POST-EPC MEMORANDUM

RE: Paradise RV Park (formerly West Mesa RV Park)

Project #1008830/11EPC-40073 – Site Development Plan for Building Permit

SP-3
MARCH / 2024

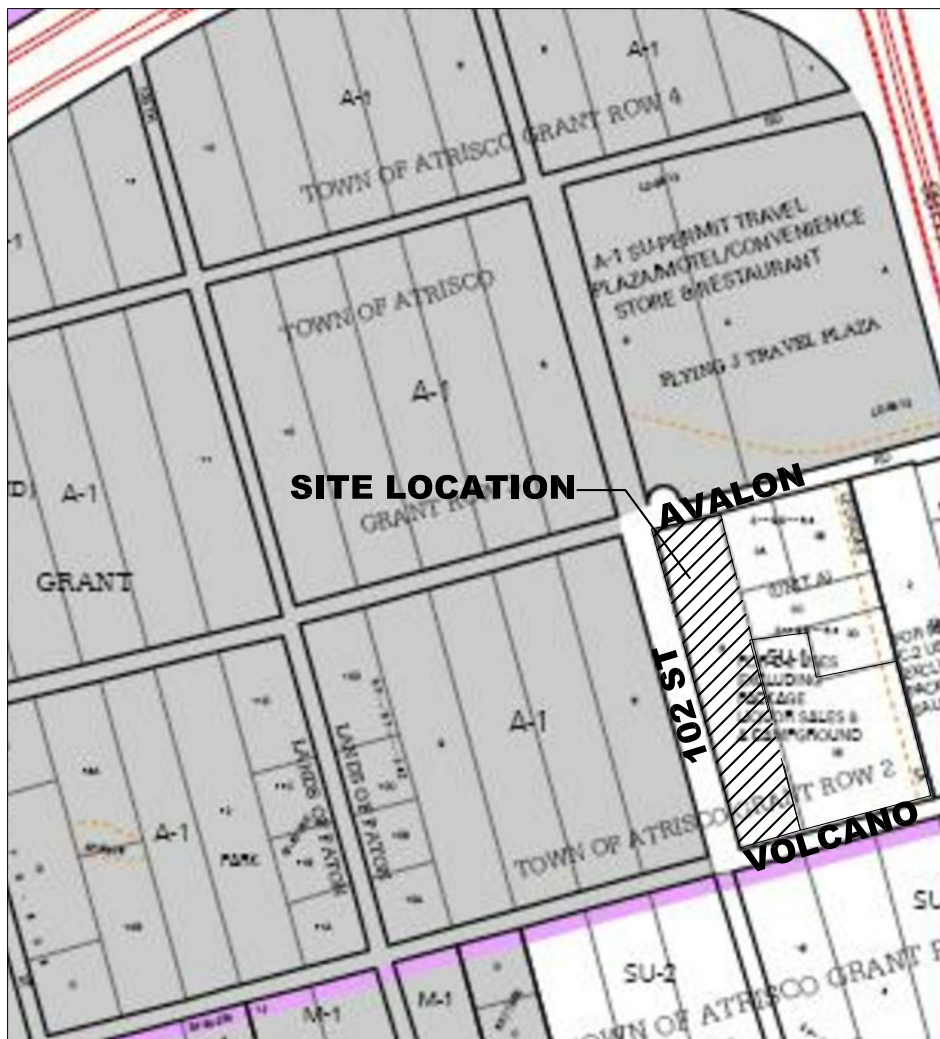
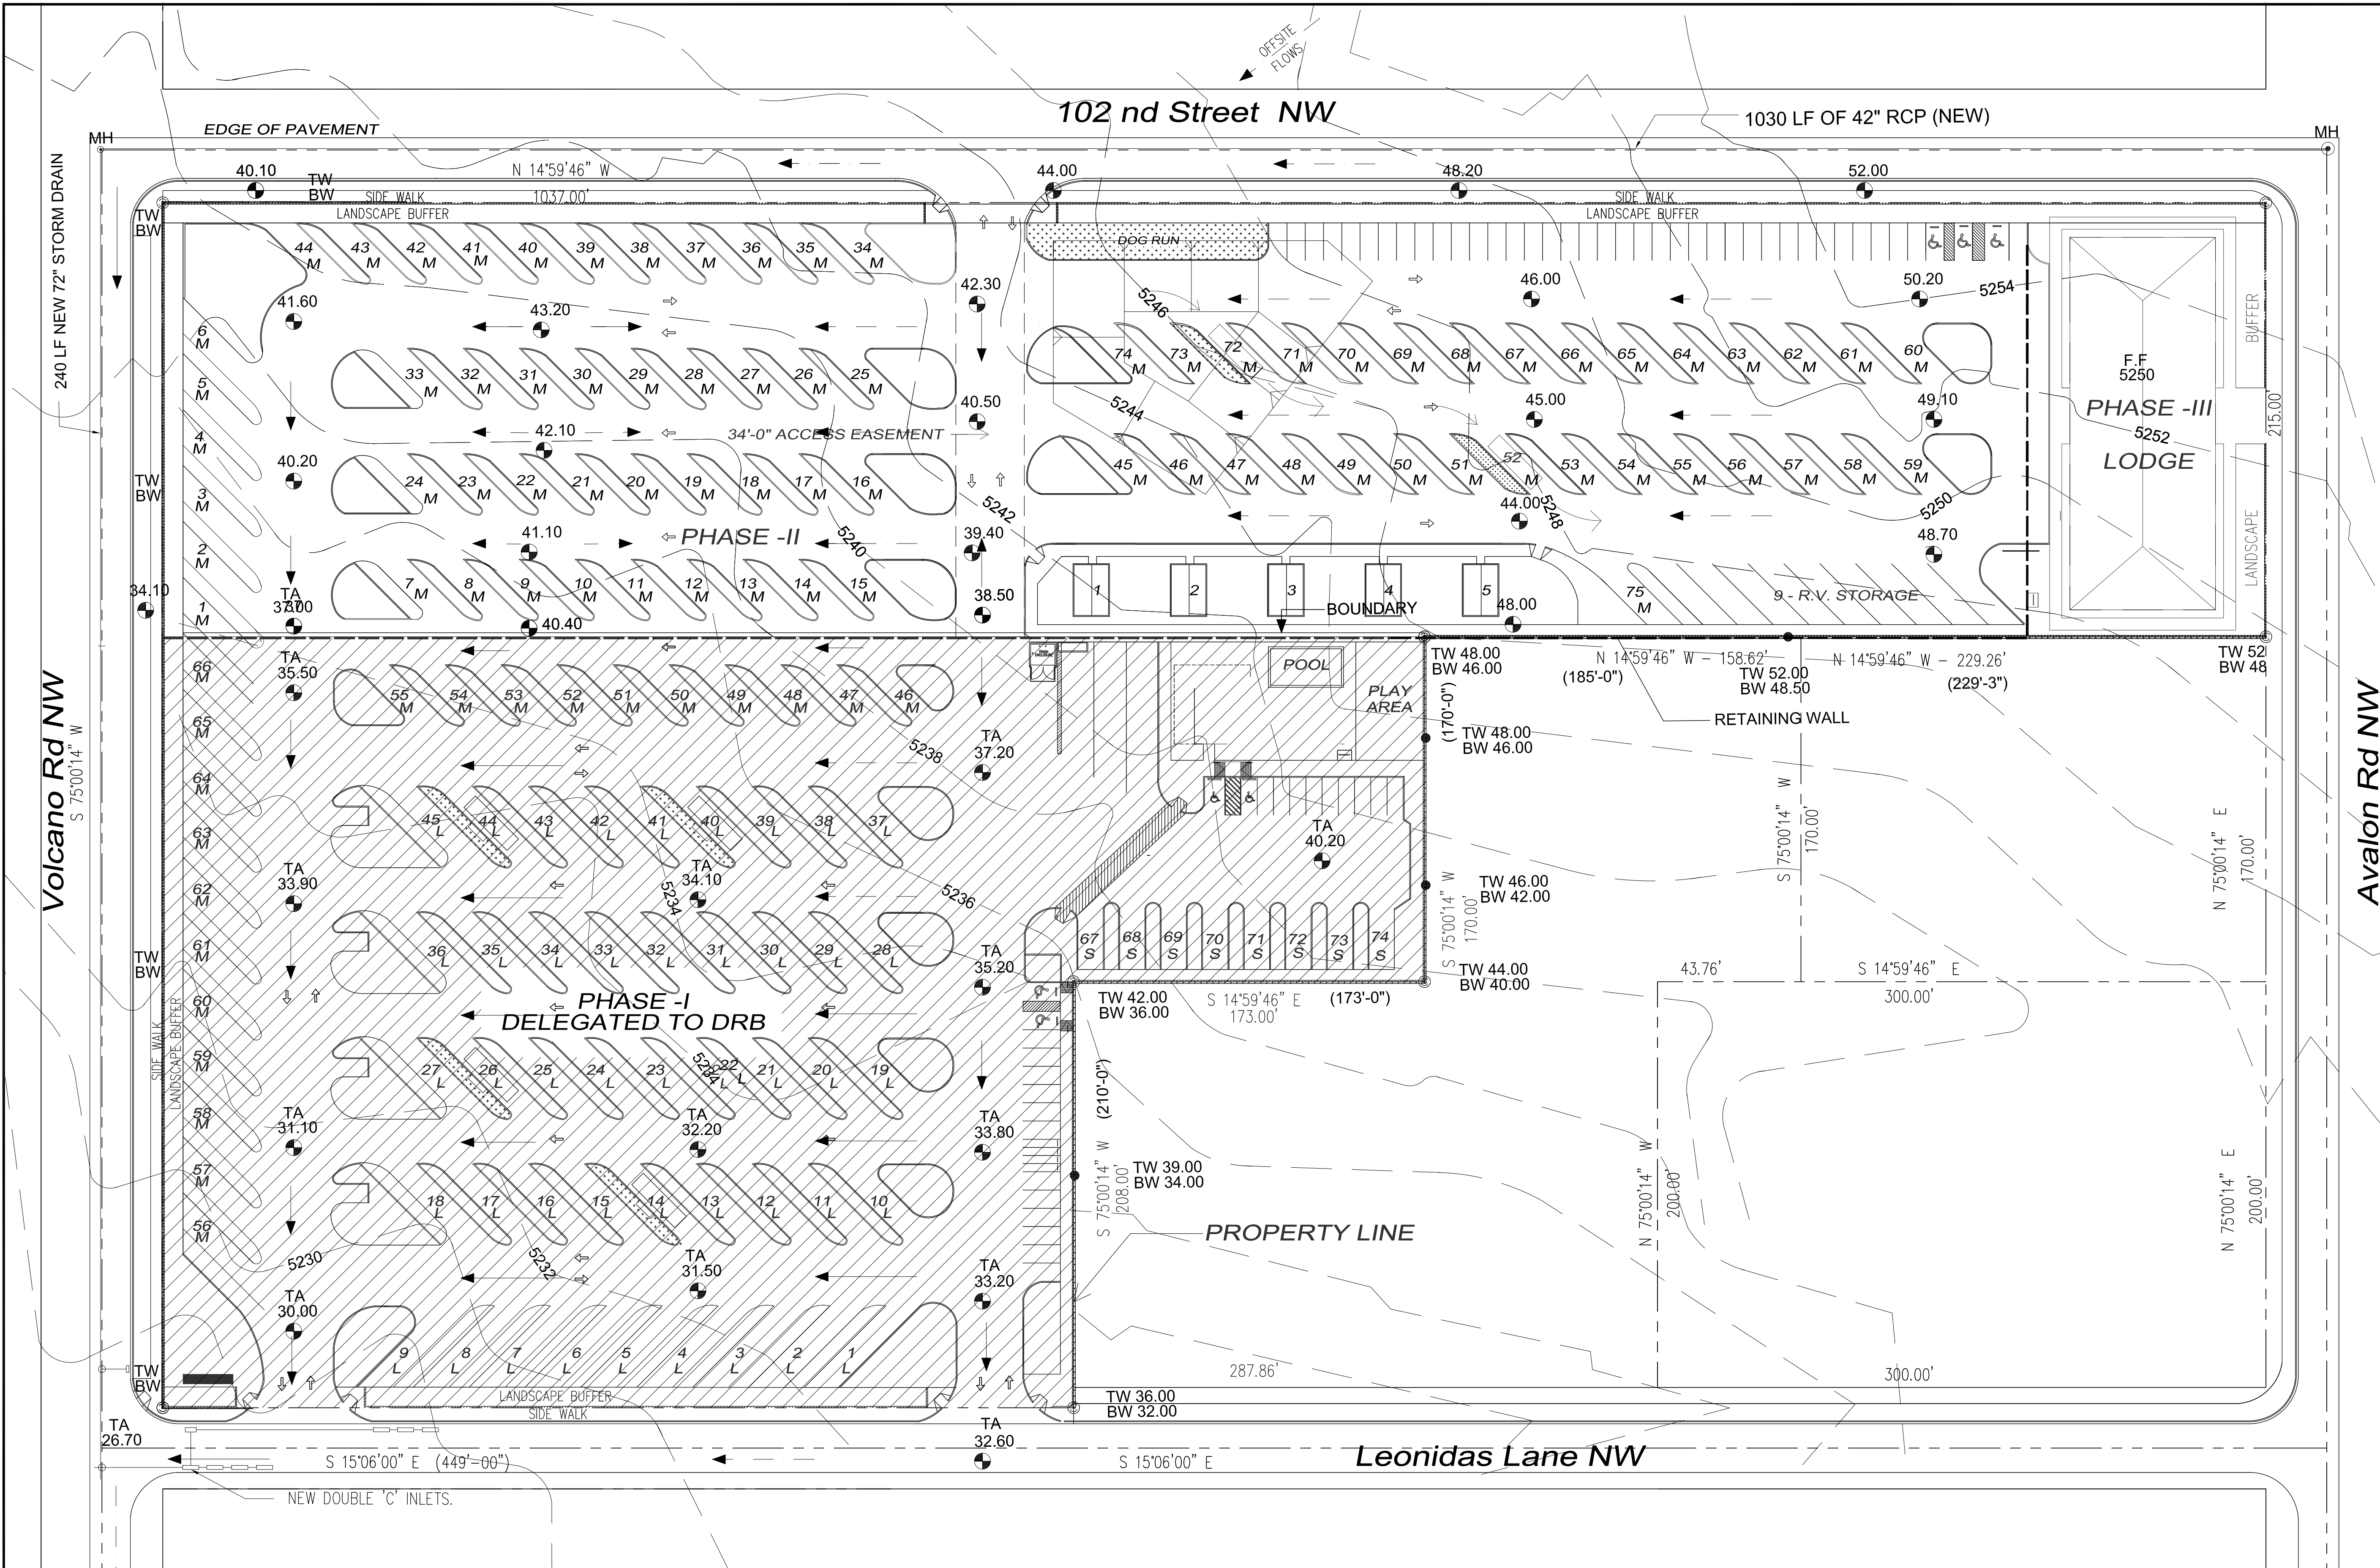
2. Condition 2 has been met. The applicant has met with Staff planners to ensure conditions of approvals have been met.
3. Condition 3 has been satisfied. Motorcycle signage and one-way signage are shown on Sheet SP-3.

7. Condition 7 has been met. Site Development Plan sheet SP-2 Keyed Note #18 states the new pylon sign has two faces. A New Sign double faced sign detail is shown on Sheet SP-3.

- 8d. ADA Car Accessible Stall Details have been added to Sheet SP-3. ADA accessible pathways from parking stalls to building are shown on Sheet SP-2.

- 8g. Leonidas Lane is noted on Site Plan sheet SP-2 as a 50' Private Access Easement with a reference to the recording information.
 - 8h. Paving markings of arrows and notation showing ONE WAY and TWO WAY traffic are shown on Site Development Plan Sheet SP-2. Detail Sheet SP-3 shows the One Way Sign detail.

C-03

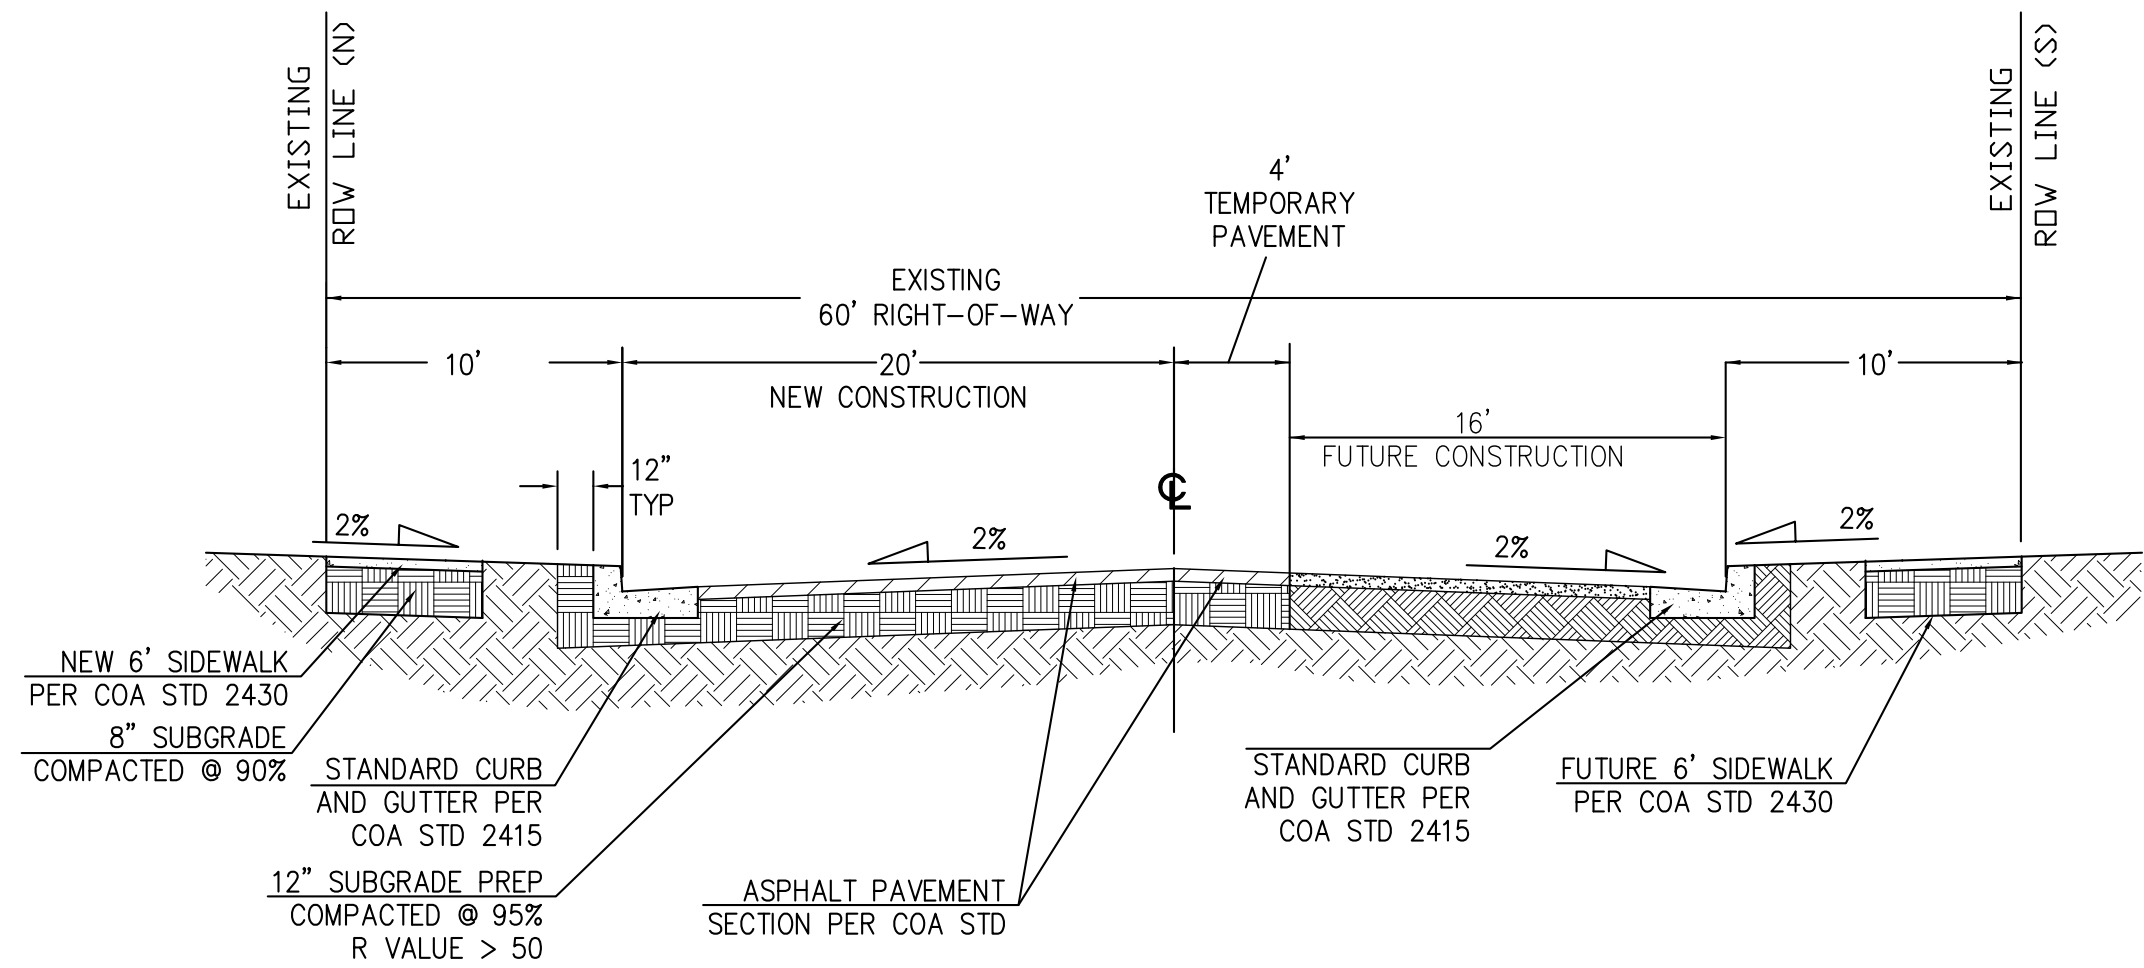
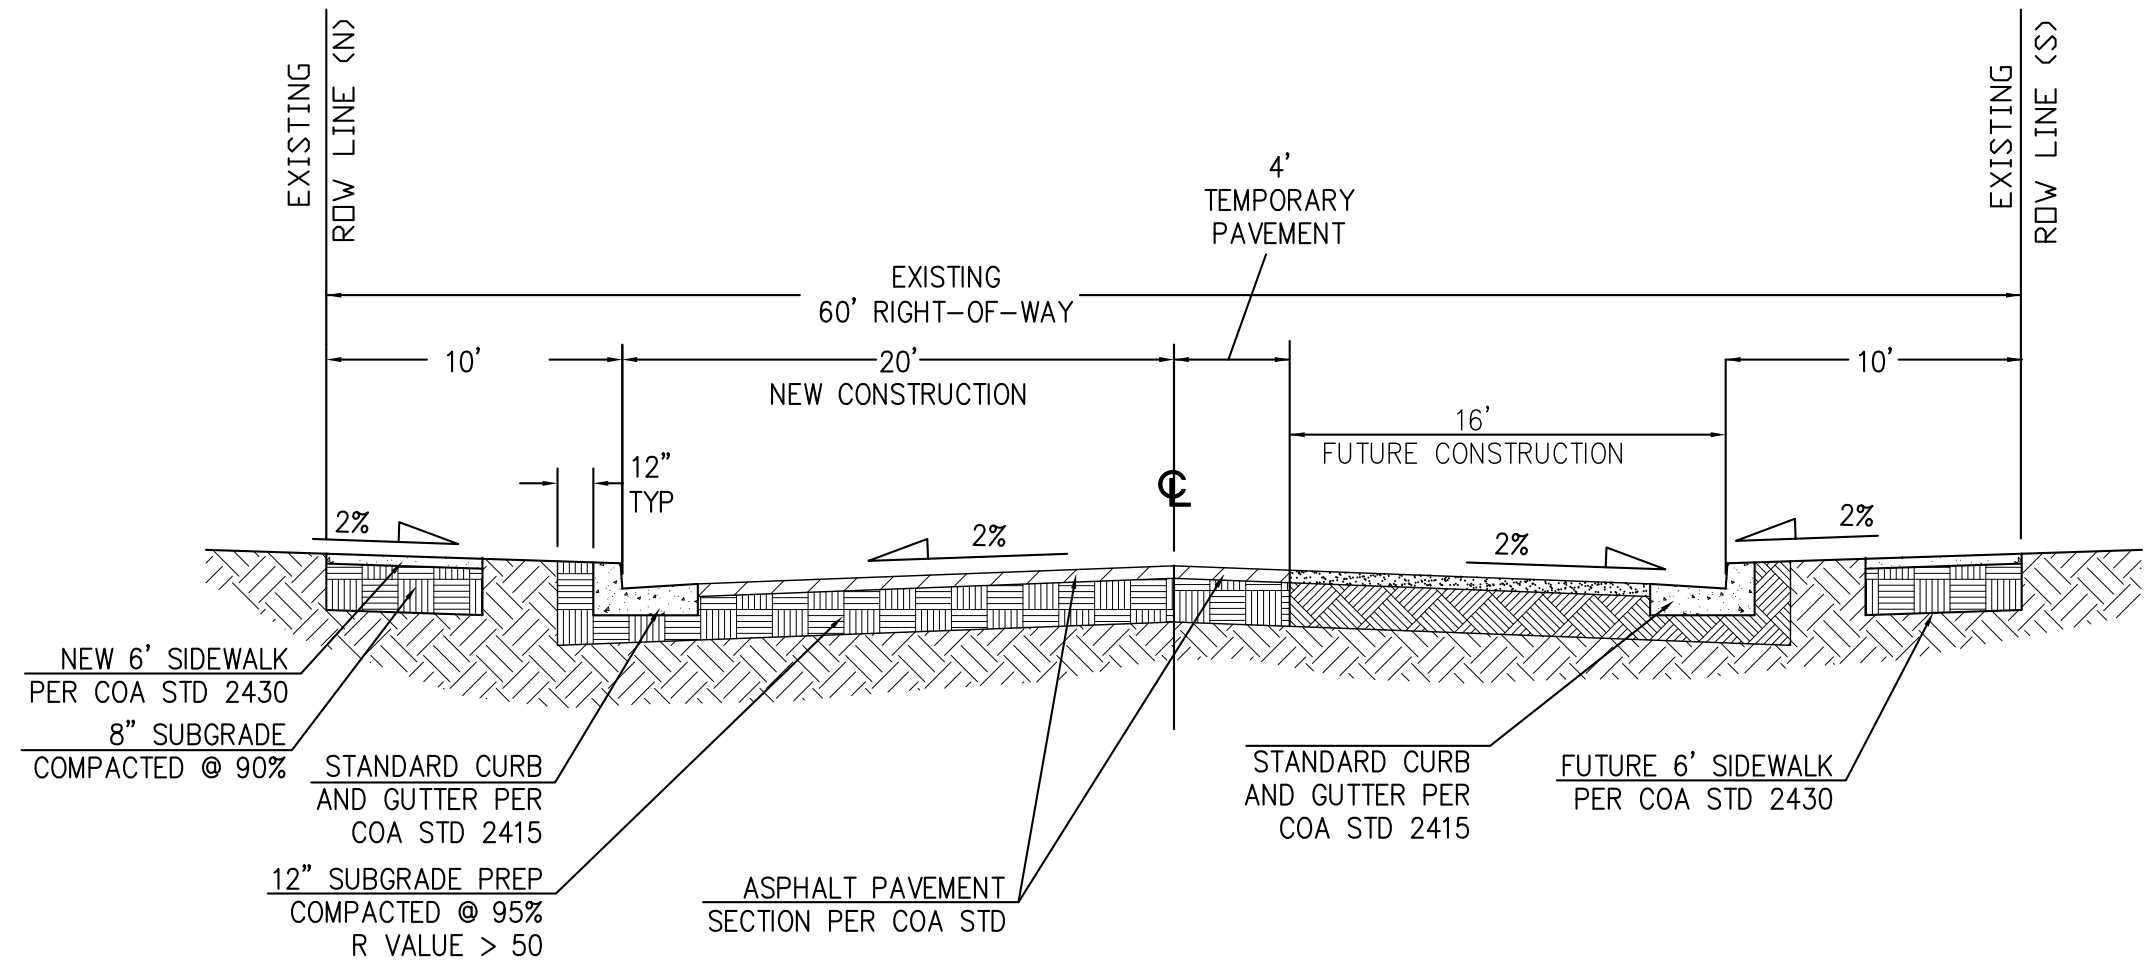
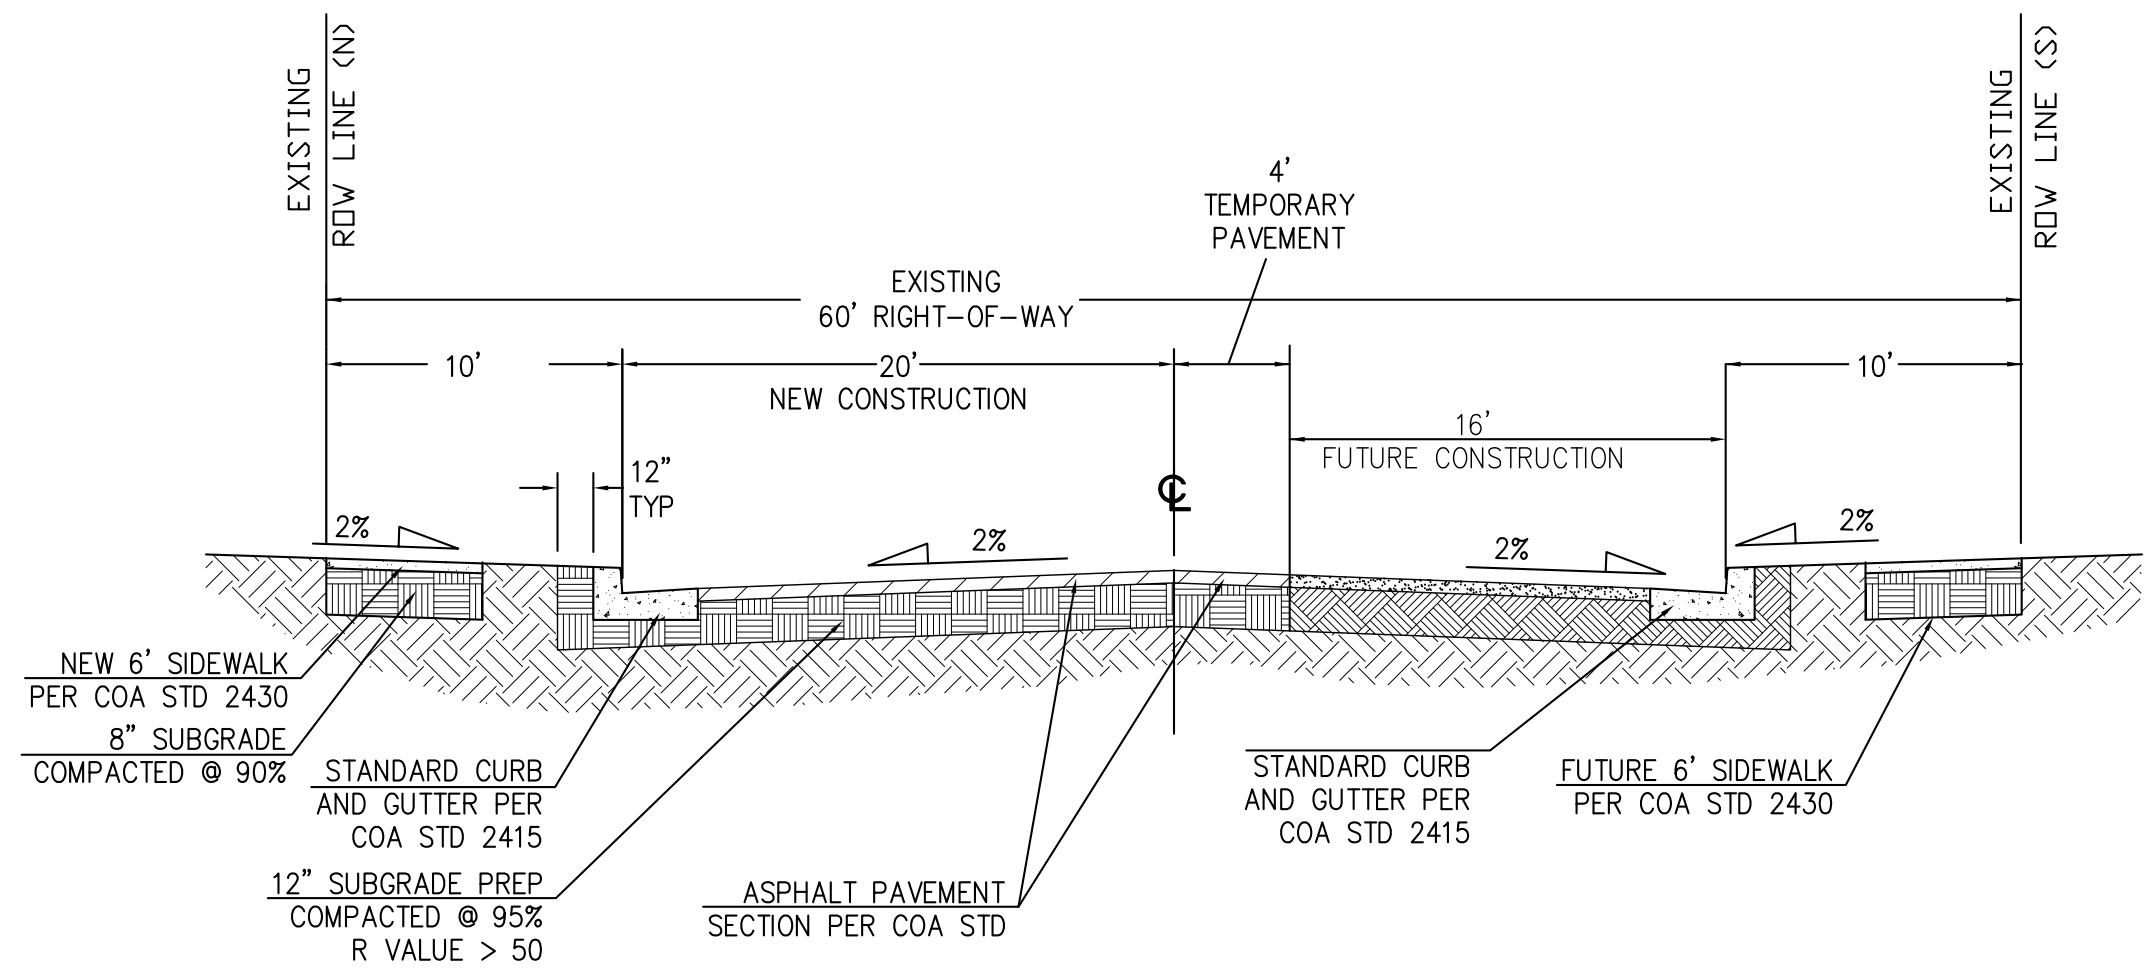
- 8b. The RV Centerline Turning Radius Template has been added to Sheet SP-2. The proposed RV routes are shown on site development plan Sheet SP-2.
 - 8c. All dimensions are labeled or noted on Sheet SP-2. Proposed road infrastructure Offsite Roadway Sections have been added to Sheet C-03.

- 8e. A 6' wide ADA accessible pathway from the roadway to the building is noted and shown on Sheet SP-2 and referenced in Keyed Note #19.
 - 8f. Limits of Pavement are shown on the Typical Offsite Roadway Sections on Sheet C-03. The cross sections note the limits of the paving to be conducted on Volcano Rd NW, 102nd St, and Avalon Rd.

- Additional Keyed Notes 14-20 were added as required by the DFT team to provide clarity to the Site Development Plan.
- The dog run is 140'x15', which was the size approved by the EPC.
- Sheet C-03, with the Typical Offsite Roadway Sections were required by the Transportation Engineer.
